Your Ref EN010088

Thursday 5 December 2019

Application by EDF Energy (Thermal Generation) Limited for an Order Granting Development Consent for the West Burton C power station

Canal & River Trust (the "Trust") Submission for Deadline Two

PROJECT	WEST BURTON C
TITLE	OUTLINE STORM WATER DRAINAGE ARRANGEMENT
SCALE	1:200
DATE	11/01/2012
DESIGNED BY	SW
CHECKED BY	CMW
DATE	November 17
PROJECT NO.	70026636-REP-0006-D4
REV	P01

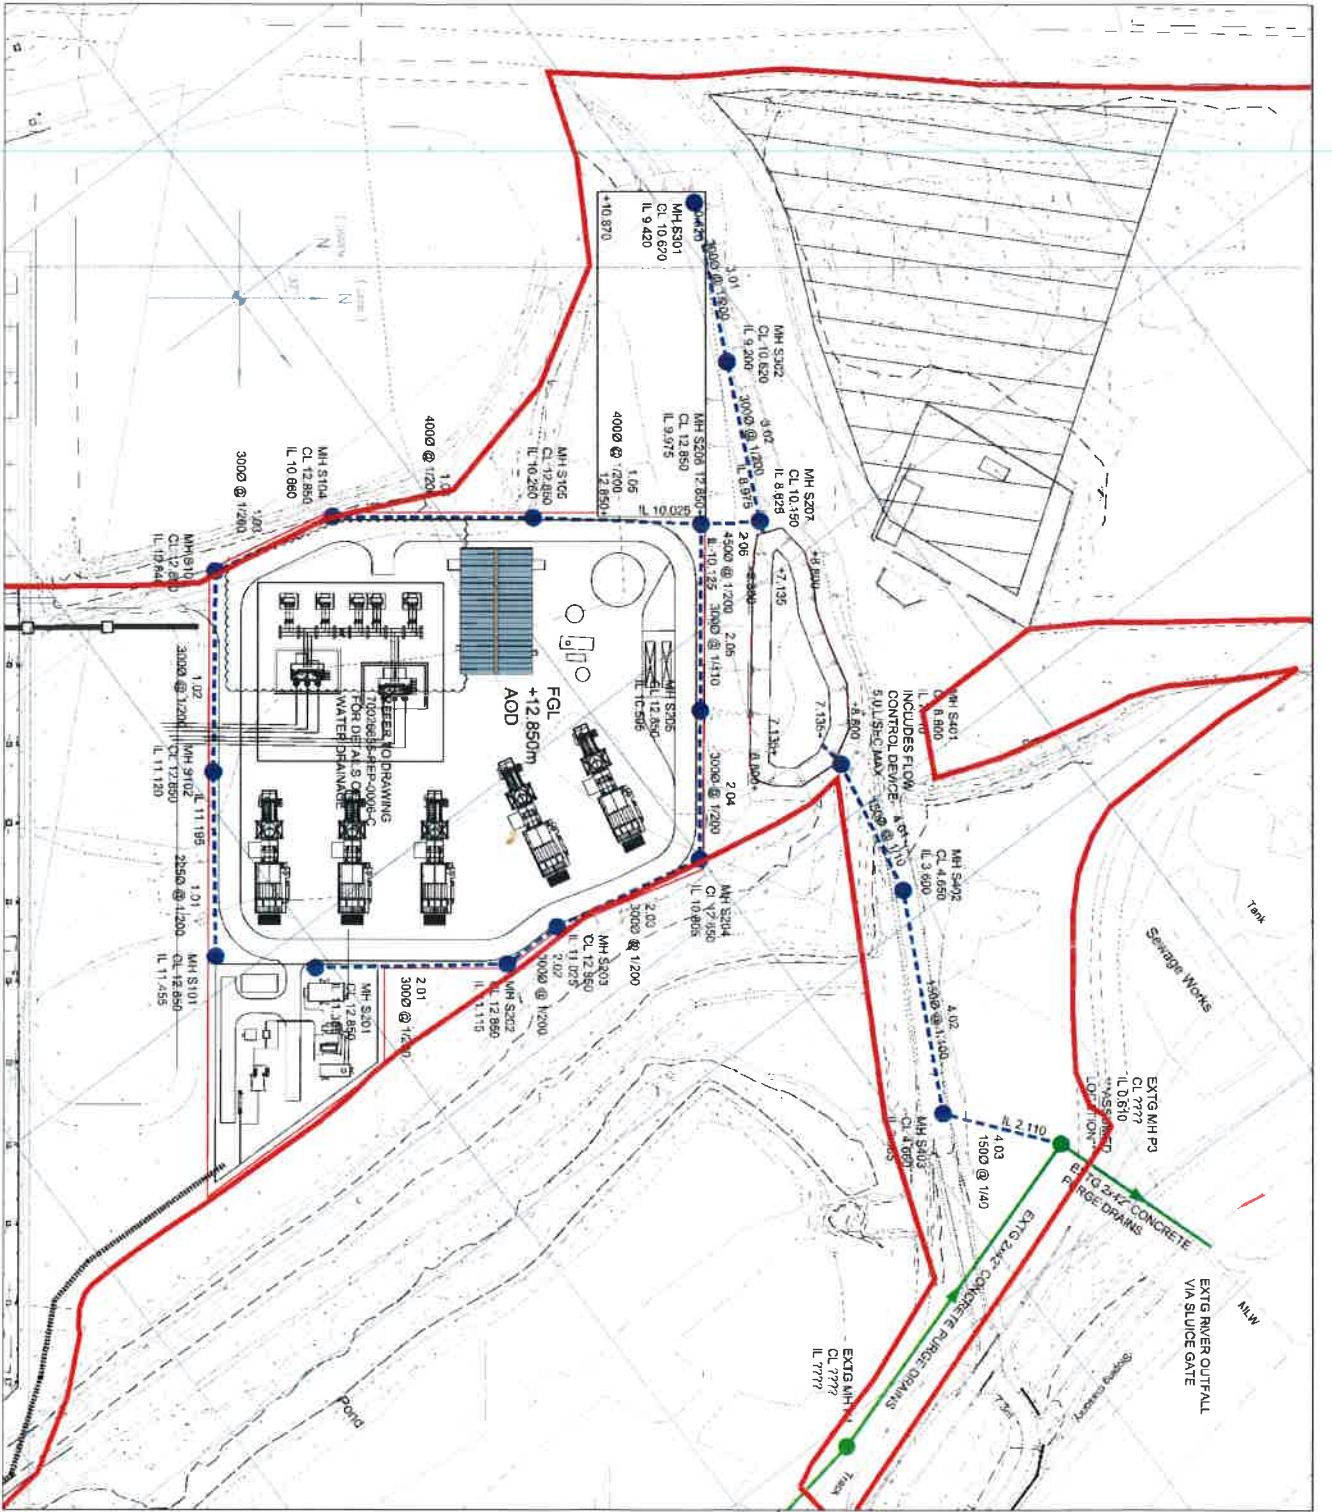
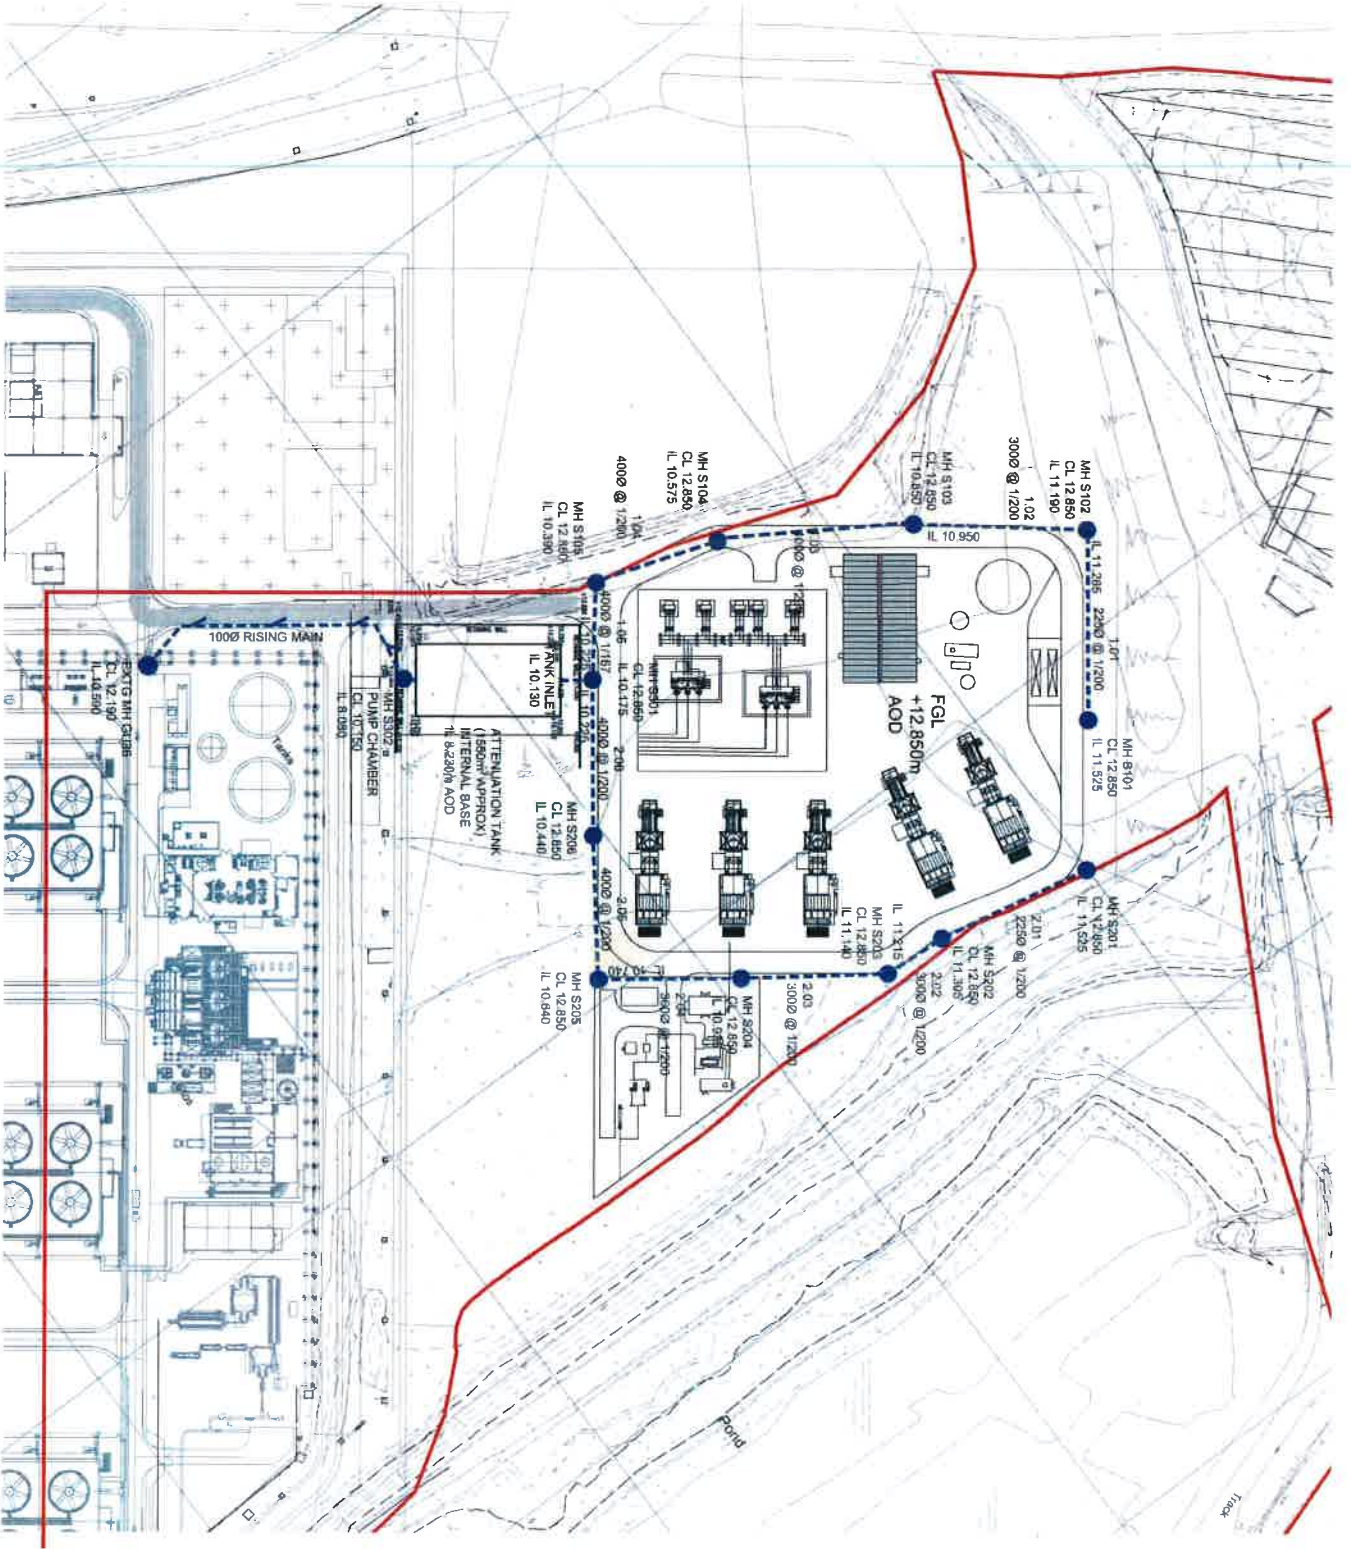
The site boundary extends to approximately 30m from the river in respect of an area required for 'work no.5', which relates to the provision of a surface water drainage system.

The existing river banks are re-enforced with sloping masonry in this location and as such may be vulnerable to the impact of, for example, vibrations caused by construction works, the movement of heavy plant and equipment etc. which could adversely impact the stability of the riverside bank and necessitate future repair work.

Whilst it is appreciated that the specific scheme has yet to be finalised, in the absence of any certainty as to which of the three options proposed is to be used and the lack of detail relating to proposed works methodology it is submitted the Trust is of the opinion that they lack sufficient detail to fully negate the possibility of harm to the waterway.

Figure 3. Abnormal Indivisible Load Route for Proposed Development

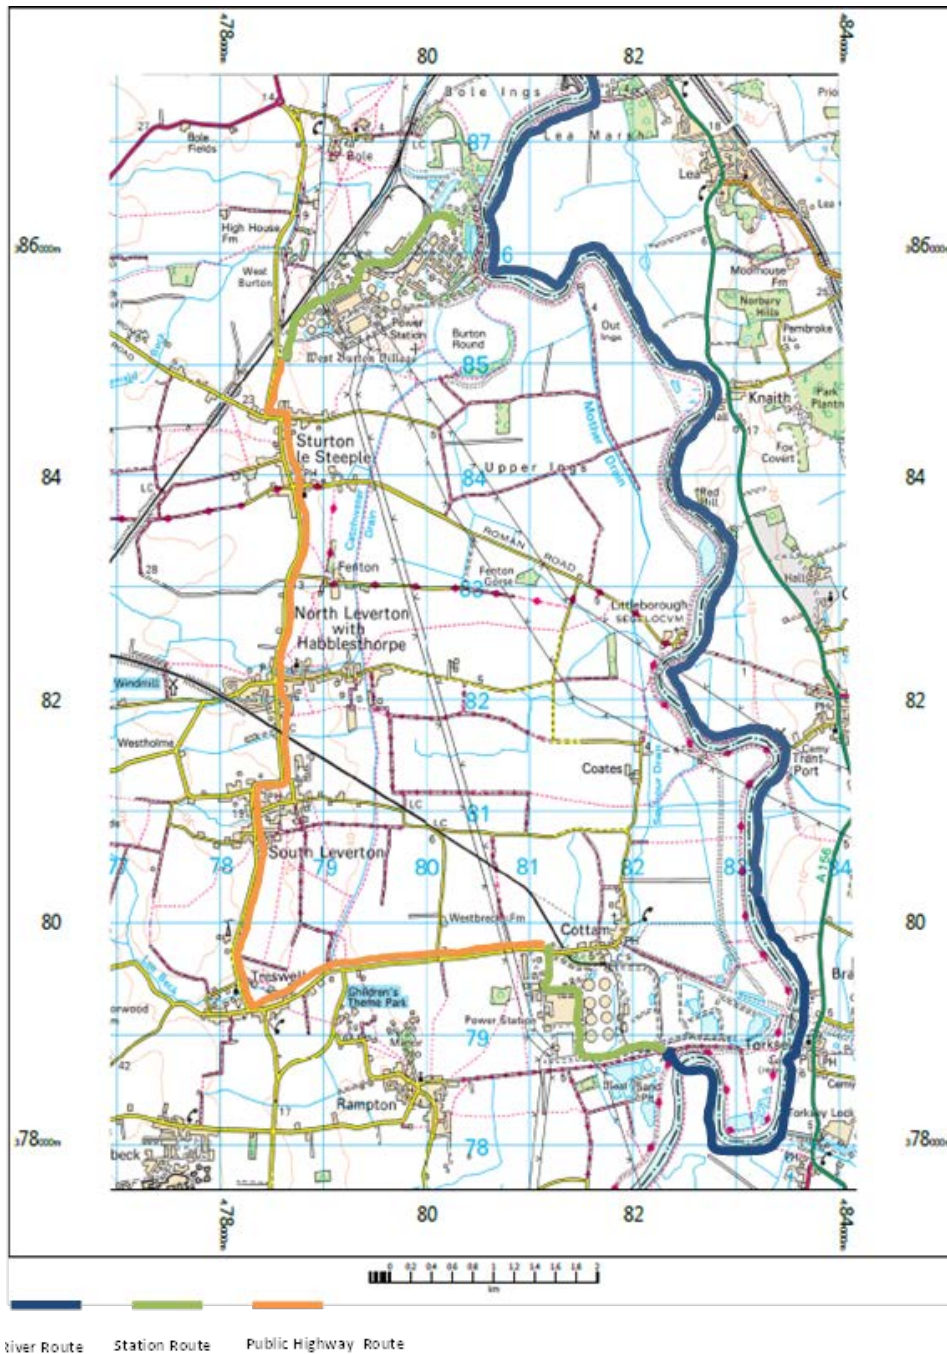
It is notable that this Requirement does not include the Trust as a consultee to the traffic and routing management plan and does not overtly comply with the water preferred policy and advisory letter to PINS in respect of this matter which seeks that "all reasonable opportunities should be taken to use waterborne transport for the public benefit ". It instead includes reference to the traffic and routing management plan including "details of the routing strategy and procedures... for the conveyance of abnormal indivisible loads, including agreed routes, the numbers of abnormal loads to be delivered by road and measures to mitigate traffic impact"

The Trust has seen no evidence to substantiate why the use of inland waterways has not been adequately considered within this Requirement and would ask that Requirement 17 should be amended to ensure that all reasonable opportunities are taken to use waterborne transport. As Harbour and Navigation authority for the River Trent, the Trust is able and willing to work with the applicant to advise on the transportation of abnormal loads by river to site, and would also wish to be consulted on the CTPM in respect of this matter.
